Project: OUF-C New Stadium Development Client: Oxford United Football Club
 Drawing Title: Hard & Soft Landscape General Arrangement Plan (sheet 4 of 9)
 Designer: CBM Checked By: AFS Drawn Scale: As Indicated Date of First Issue: Sept 2023
 Drawing Number: D3263 FAB 00 XX DR L 1104 Revision: PL03

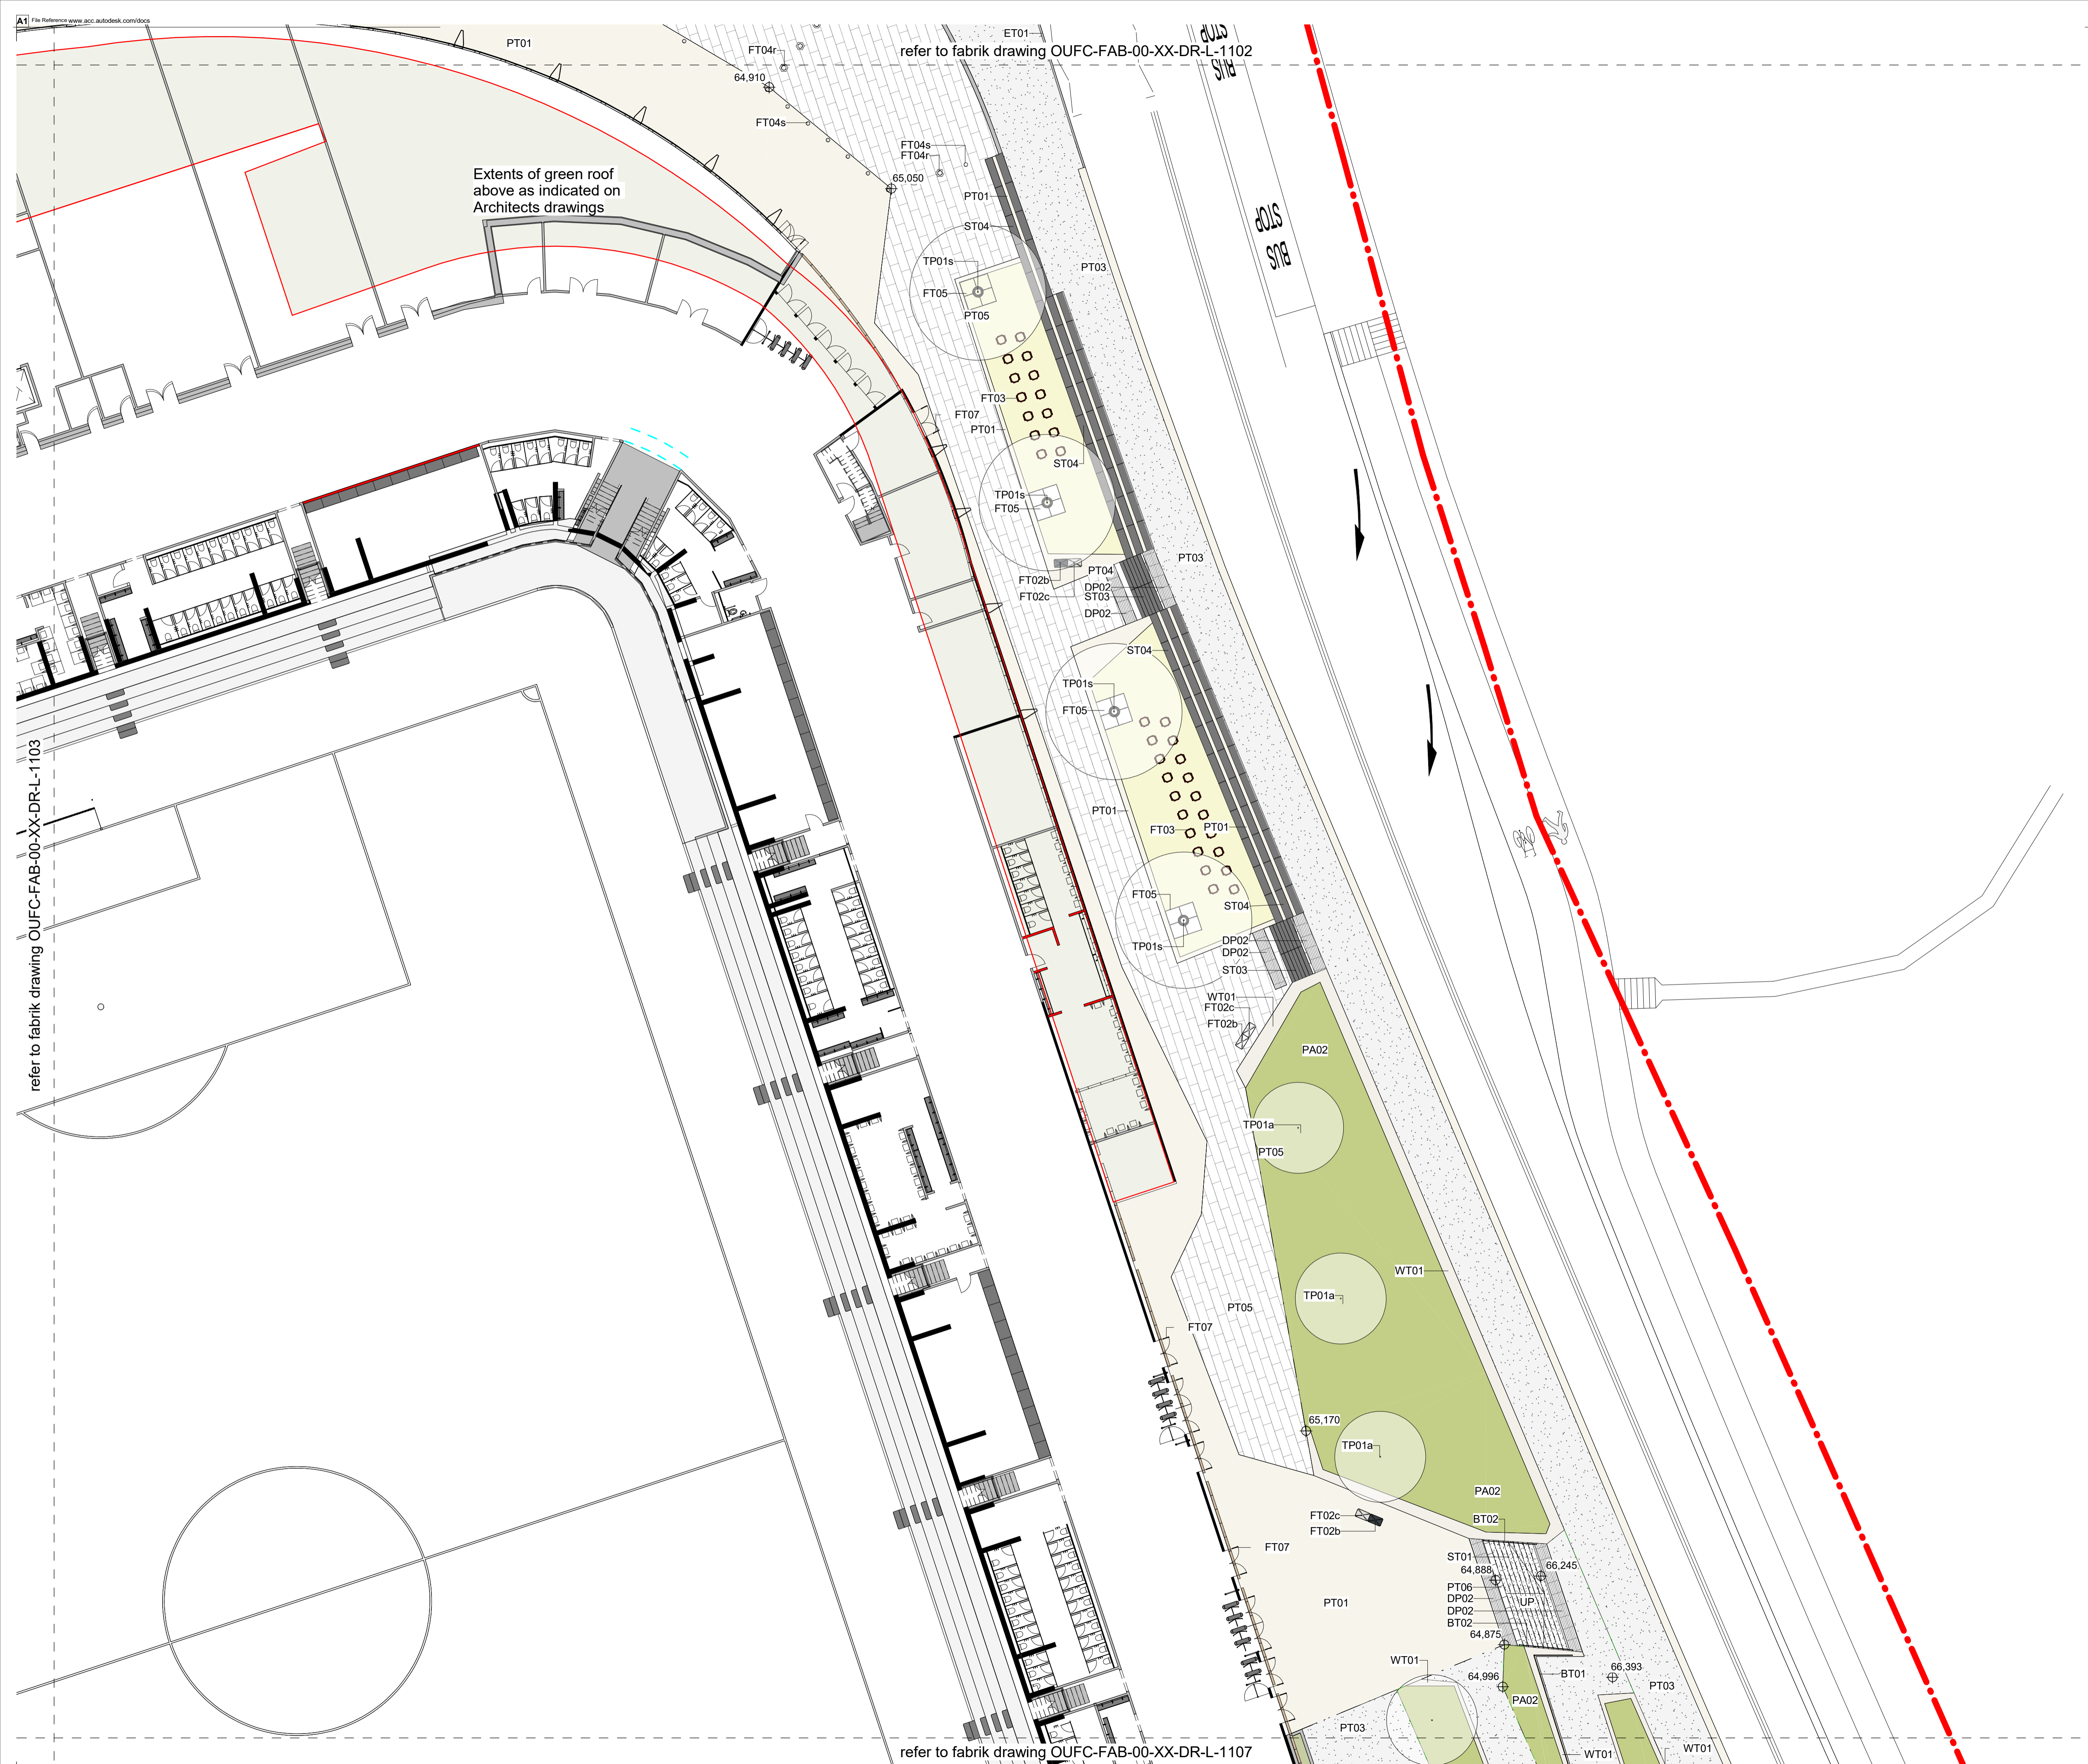
The proposal will result in the total loss of 17 trees; 5 groups of trees and the partial loss of 2 groups of trees. The protected and biodiverse woodland to the south of the development will be adversely affected by pollution, light, noise etc

Measures to 'deter' access are totally inadequate. Large numbers of people onsite will inevitably lead to overspill into the woodland. The planned deterrent to entering the woodland will be a hedgerow (as yet to be planted), scrub planting and attenuation features. This will be ineffective with 16,000 people onsite.

Two oaks with Tree Protection Orders (TPOs) are planned for removal to allow access. These have bat roosting potential and are protected by TPOs for a reason and should therefore remain.
